GRANT HAYS ASSOCIATES

DATE: May 17, 2016
TO: Jennifer Bartlett – Maine State Fire Marshal Office
FROM: Mike Hays
RE: Foundation Brewery Expansion
Permit Review Comments
CC: file

Attached are the revisions to the Permit drawings which address your comments dated 4/22/16. All the revisions are Rev-Clouded with a Delta 1 designation. Please let me know if you have any additional questions.

**A7**

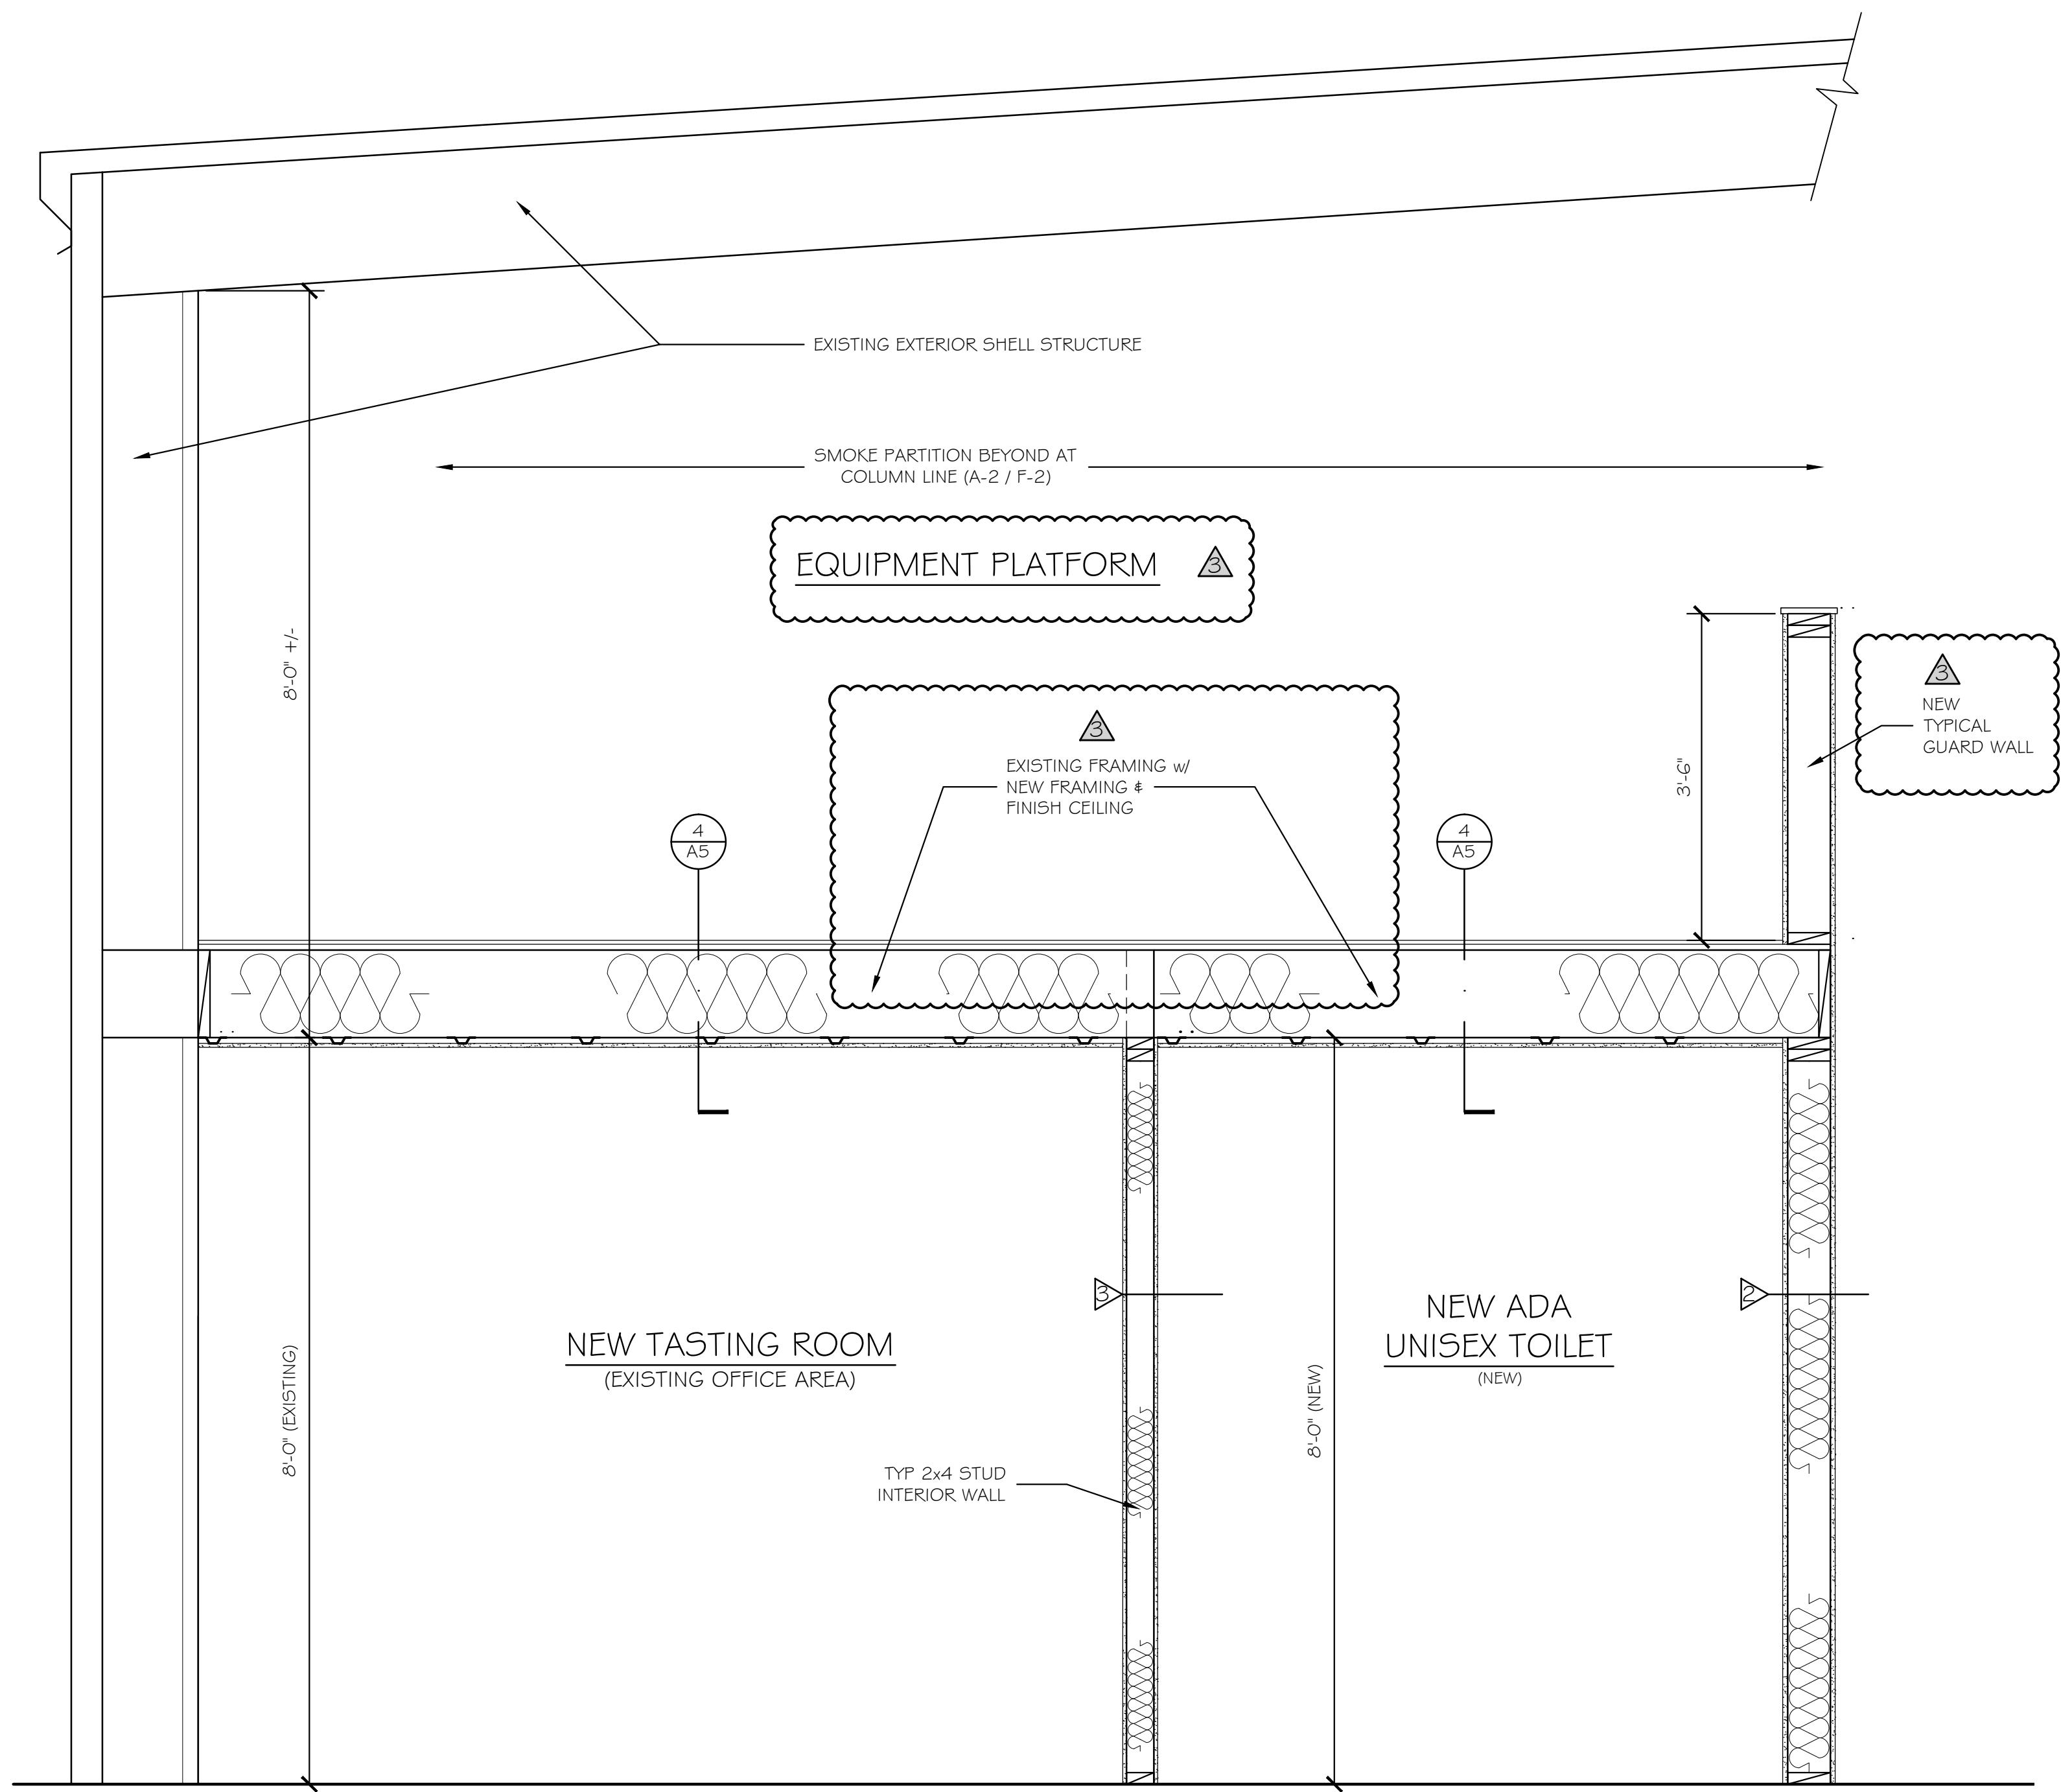
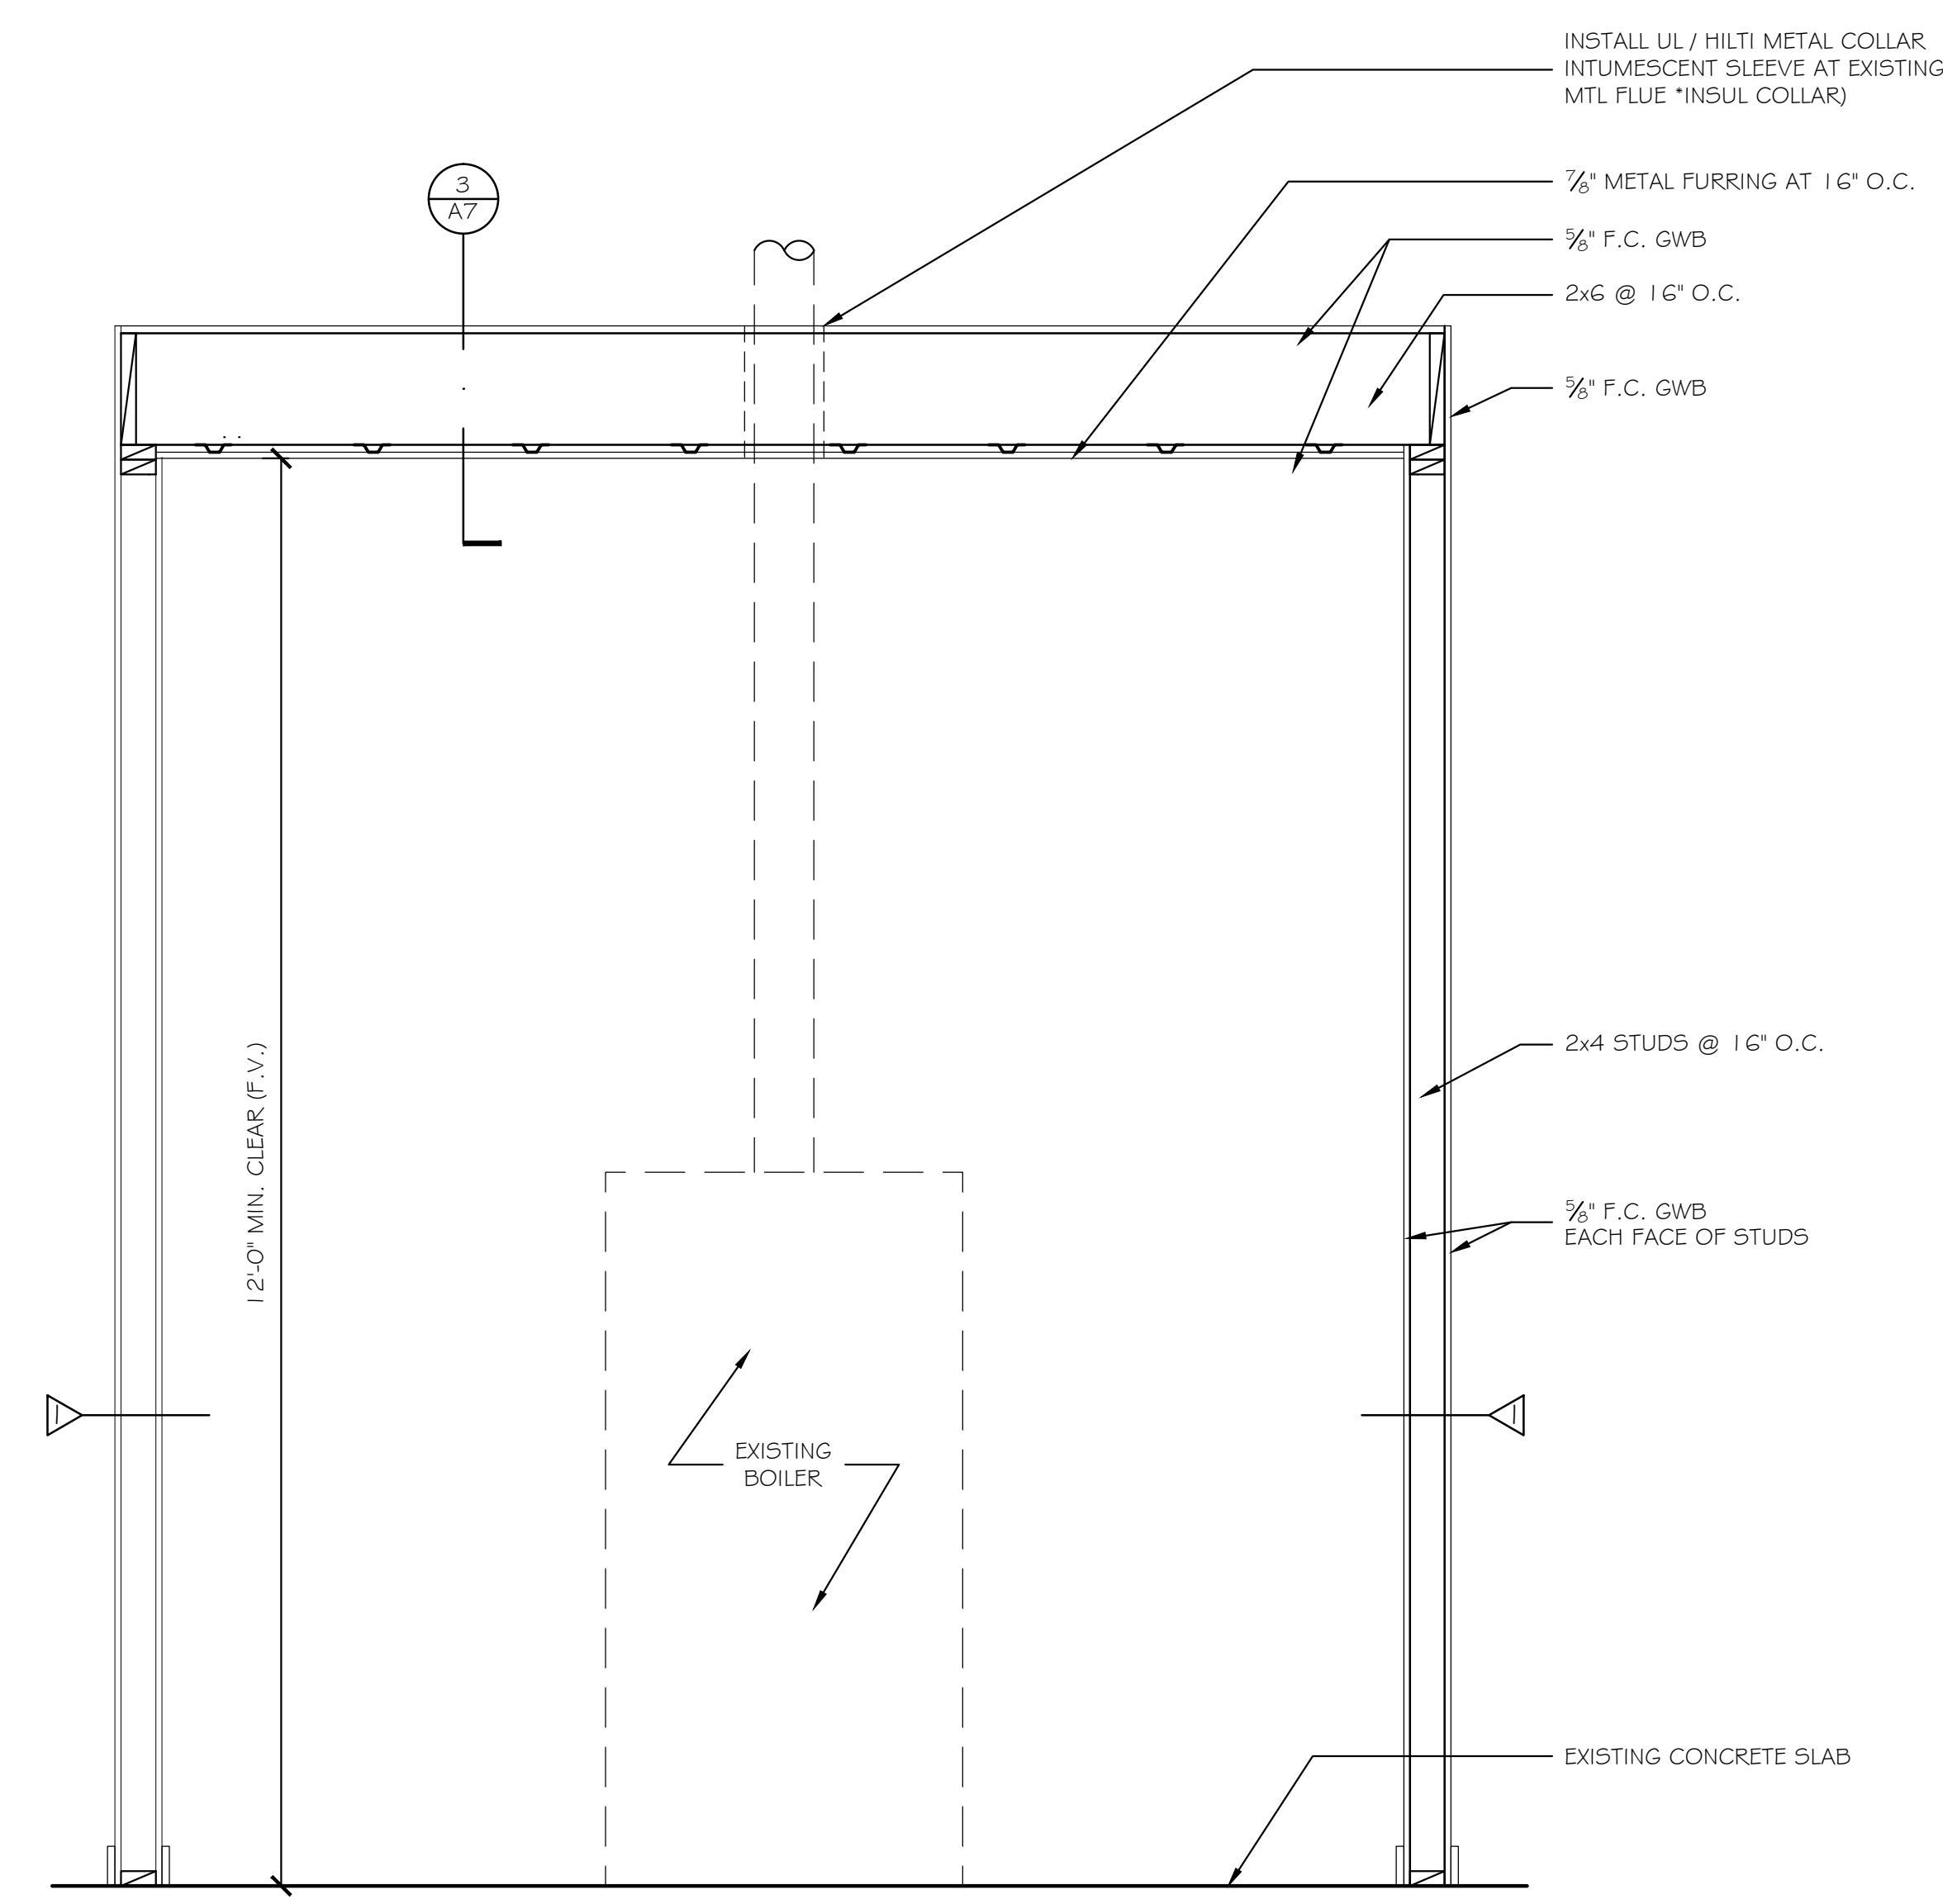
1. Added section thru New One-Hour Rated Boiler Room enclosure at the existing boiler in Production 105.
2. Added section thru New ADA Toilets depicting extension of existing mezzanine floor structure above over new Toilets for bearing condition.
